Comments for Planning Application 21/00167/HHD

Address: 4 Fox Close Bampton Oxfordshire OX18 2NH

Proposal: Demolition of existing conservatory, garage and single storey rear and side structure.
Erection of two storey side and single and two storey rear extensions.

Comment Details

Drawing Title: **Proposed Floor Plans**

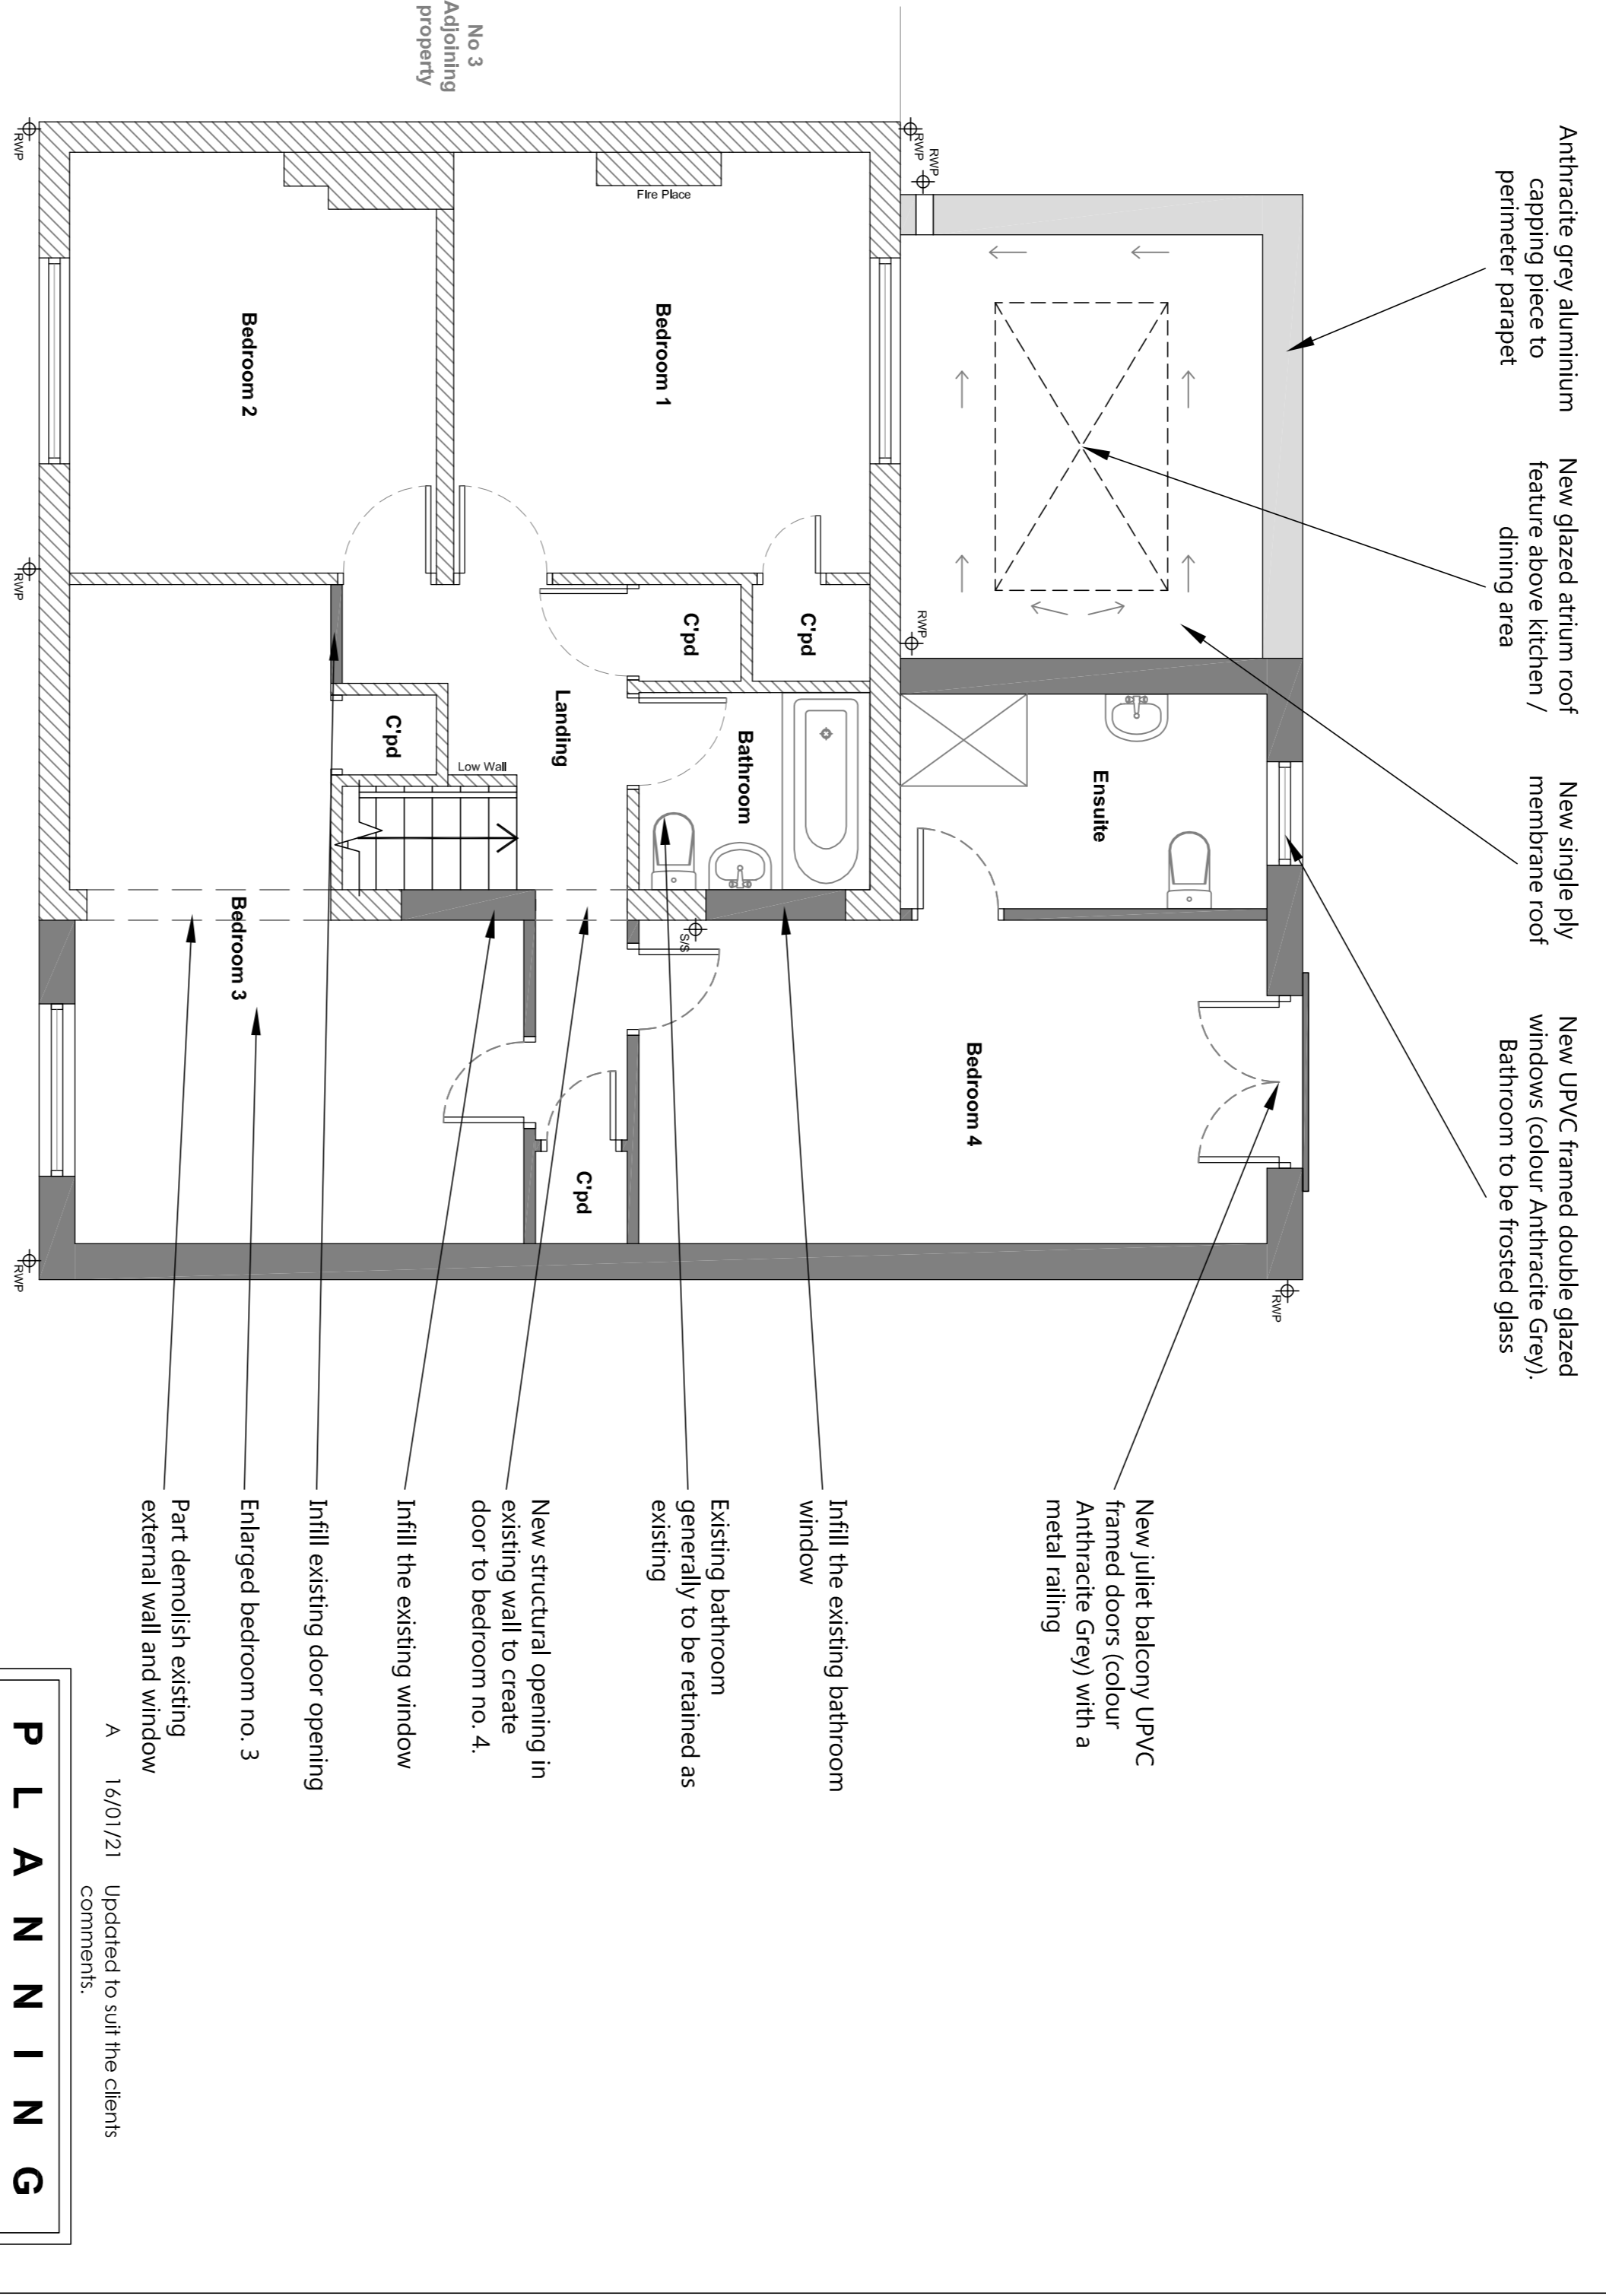
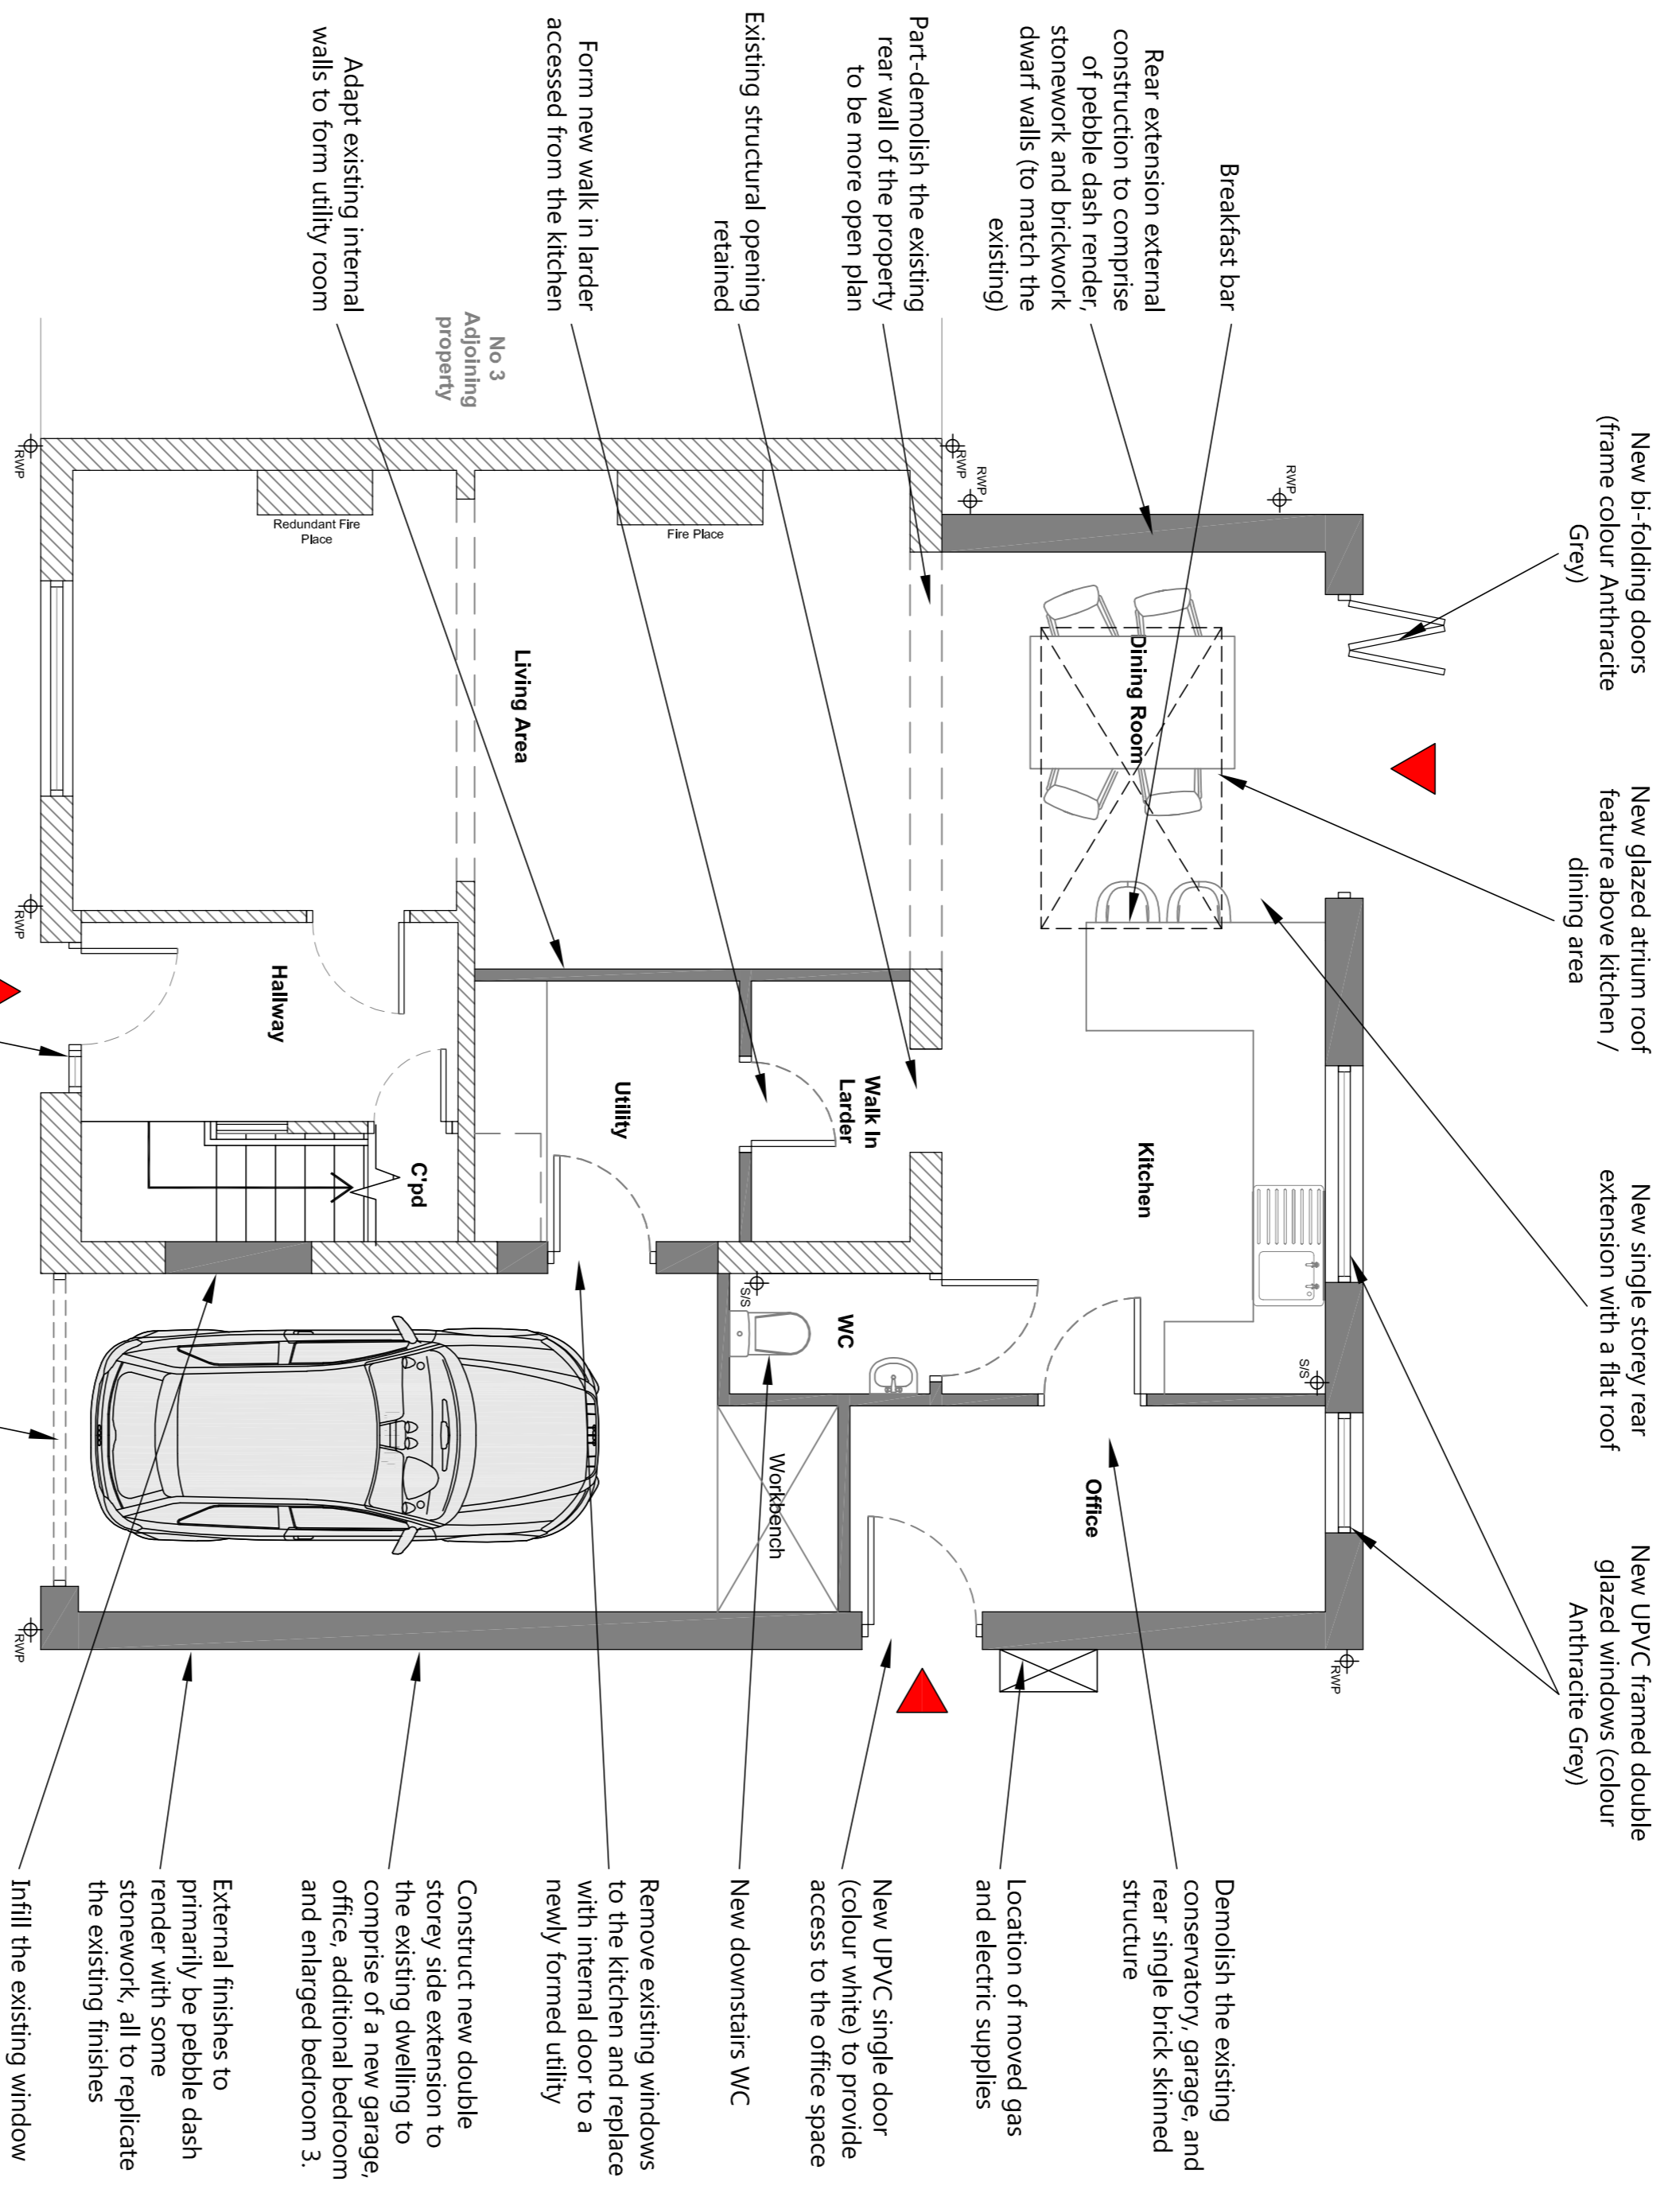
Loss of Privacy: from proposed second storey planned rear bedroom and balcony. The view from this new window and second floor extension will give a view into my sitting room. I note on the proposal that no window was planned to the side to avoid any potential overlooking the neighbouring property, however side bedroom windows already exist in both properties. This same consideration of 'overlooking' has not been given to my property which is to the rear.

As upper bedroom side windows already exist in no 4 and neighbouring house, would it not be more appropriate to keep windows to side of the property as there is already a precedent for this and less risk of 'overlooking' than relocating to the rear of the property?
